SUBJECT: Engineering Review Comment
Mountain View Electric Association Inc. (MVEA)

Project Name: Grandview Reserve Filing 1 – Final Plat

Project Number: SF2311

GRANDVIEW RESERVE FILING NO. 1  
FINAL PLAT

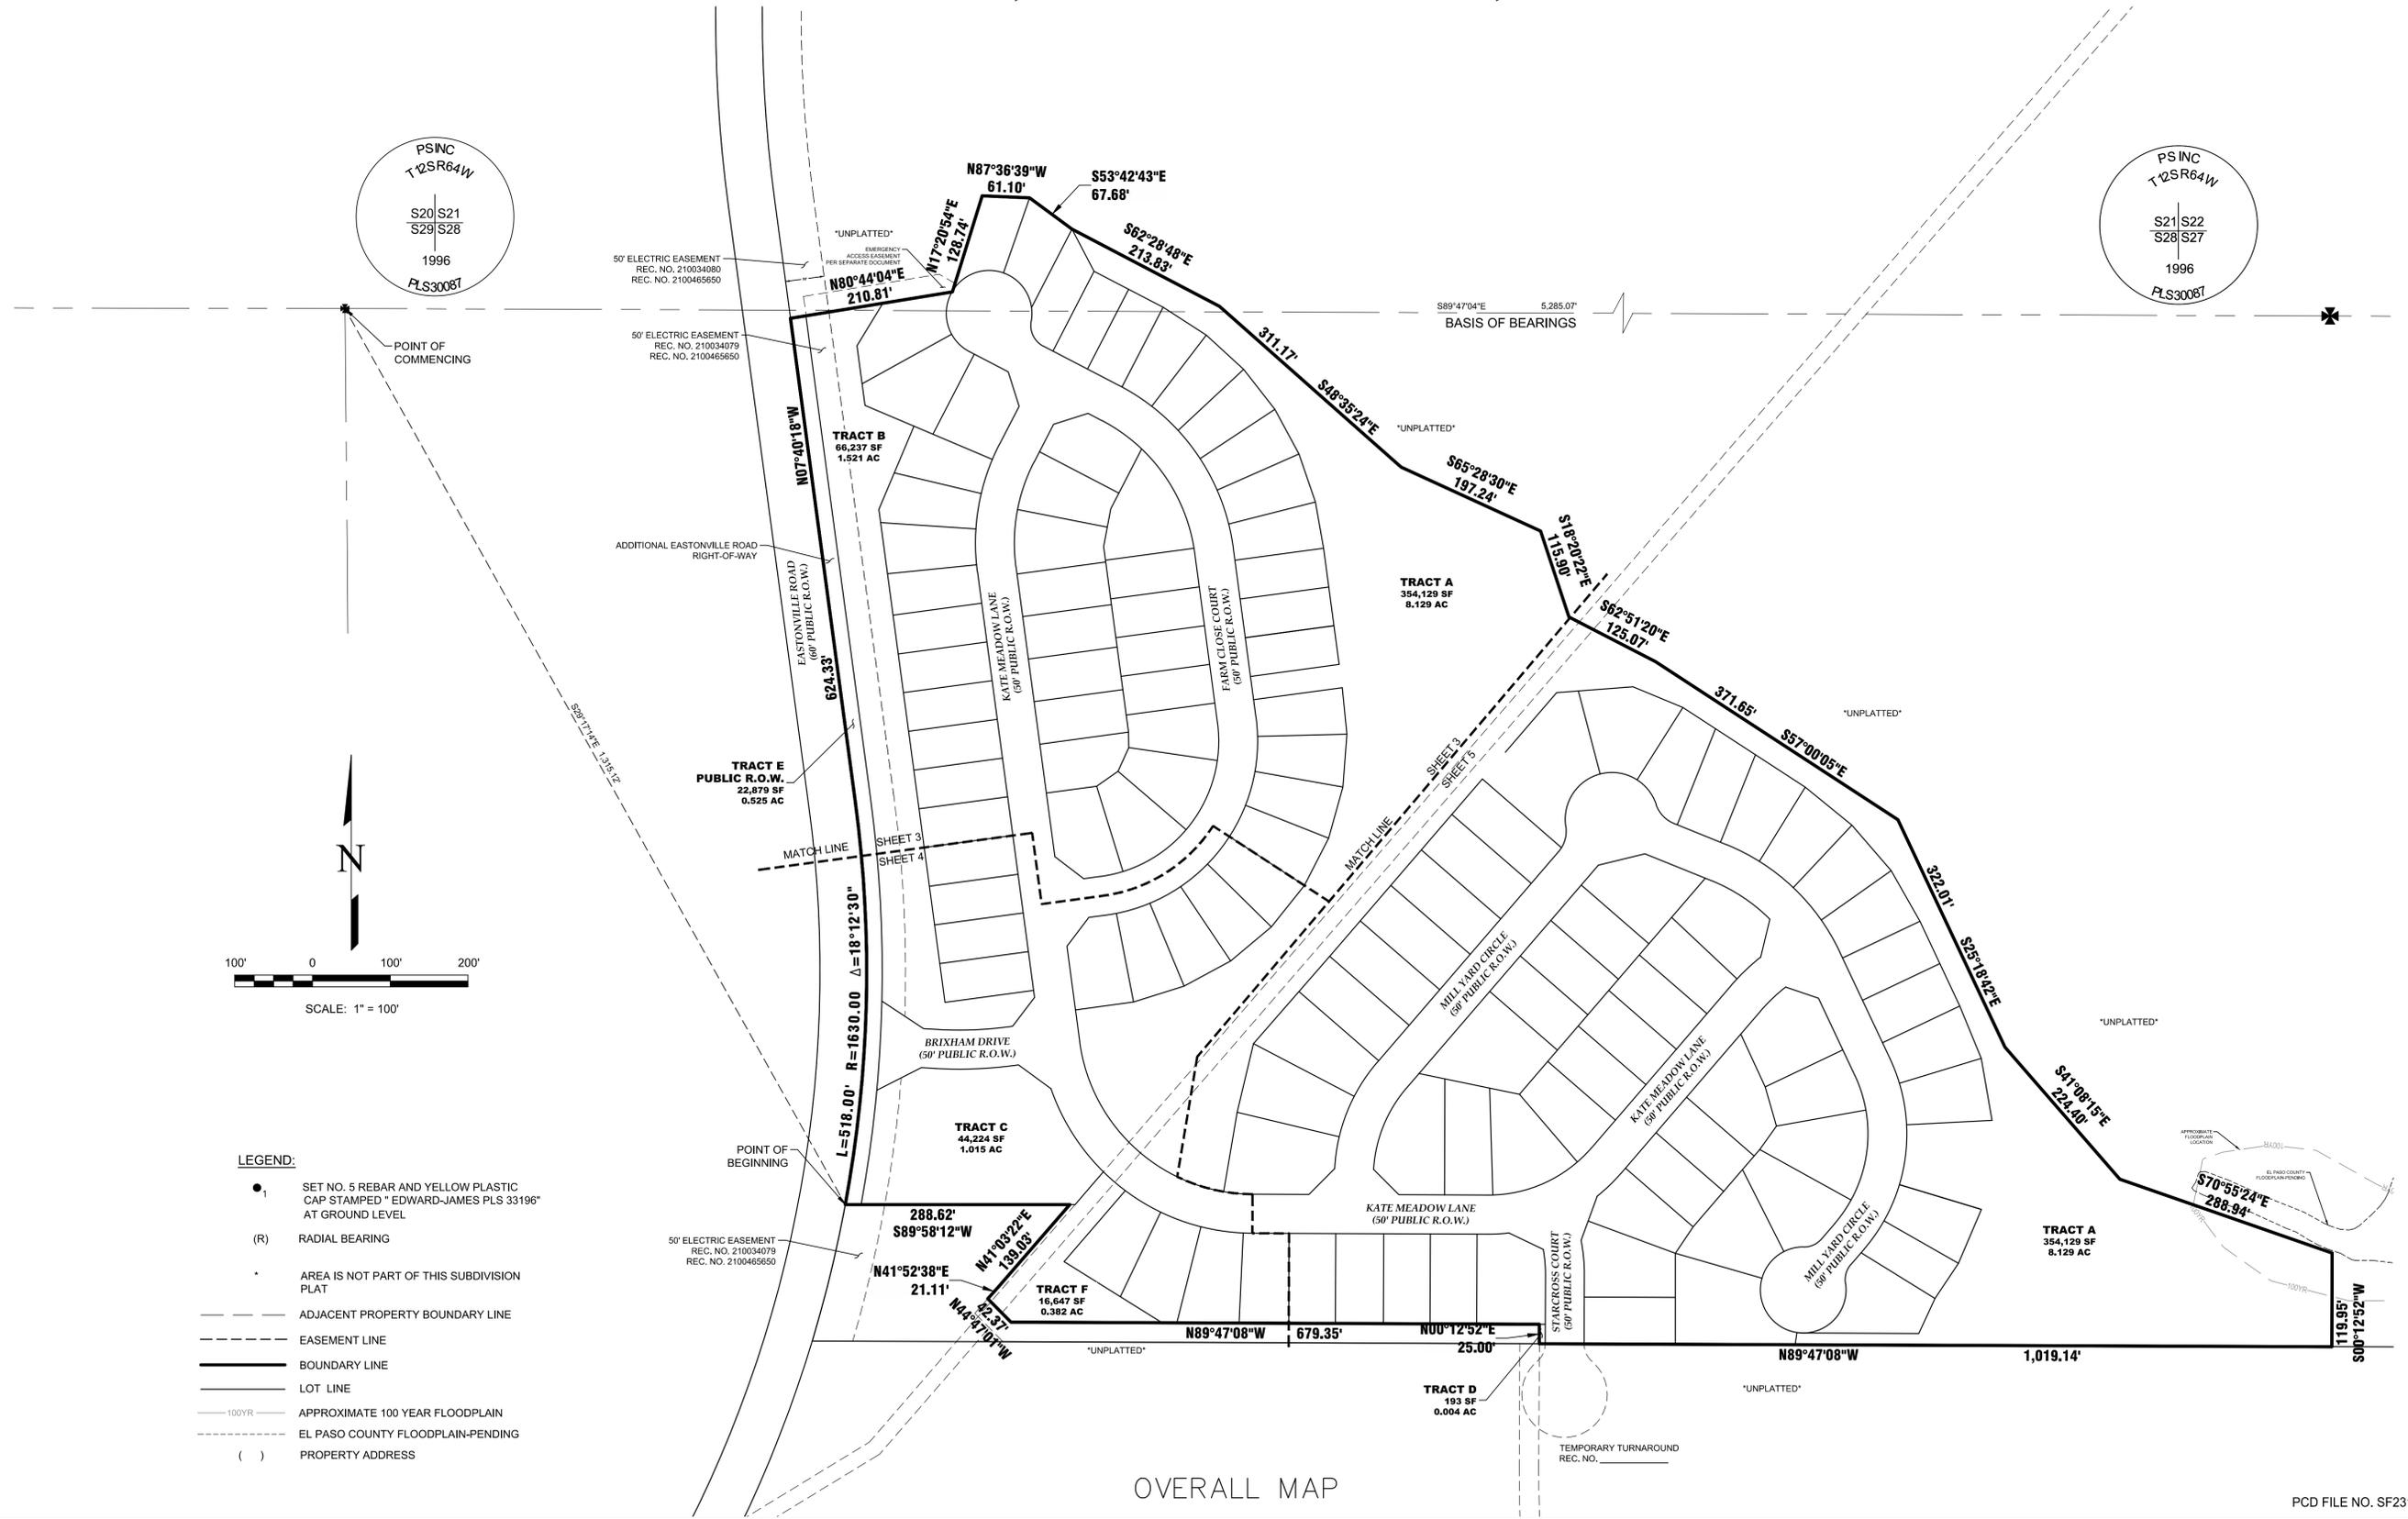
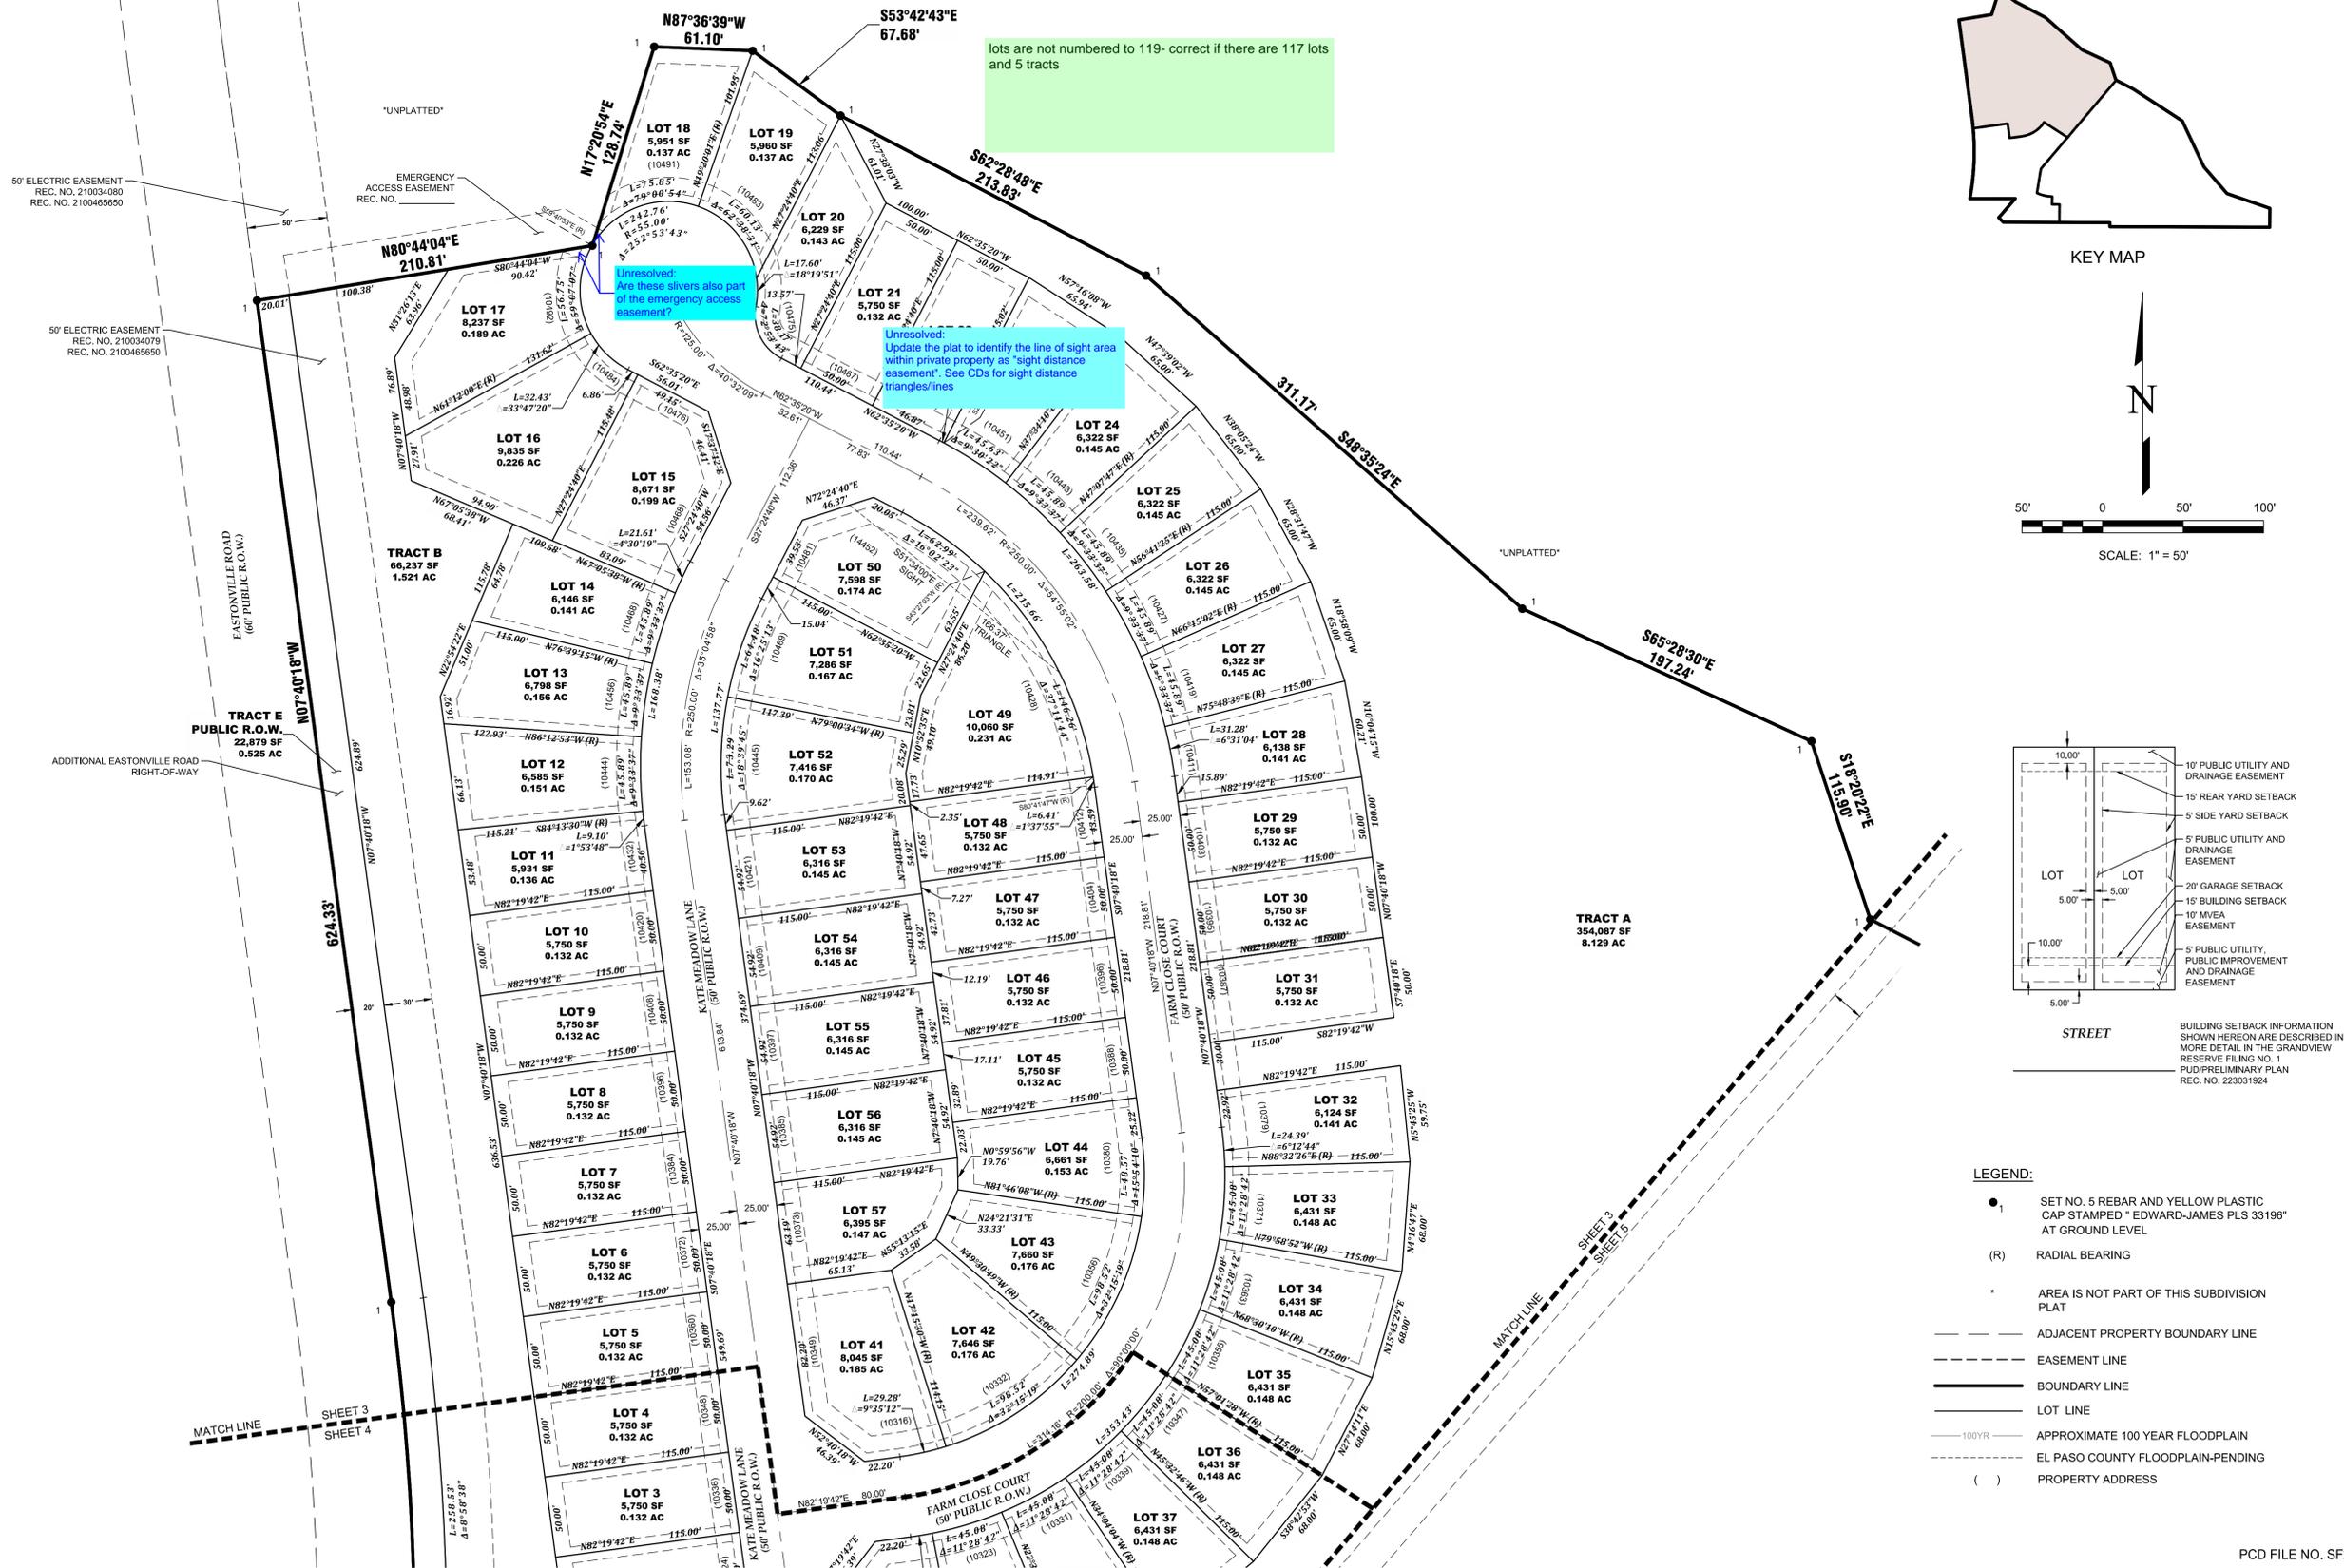
MVEA does not object to the easements shown on General Note #8. MVEA does request that Utilities be added to the Tract Table for consistency with General Notes 14.
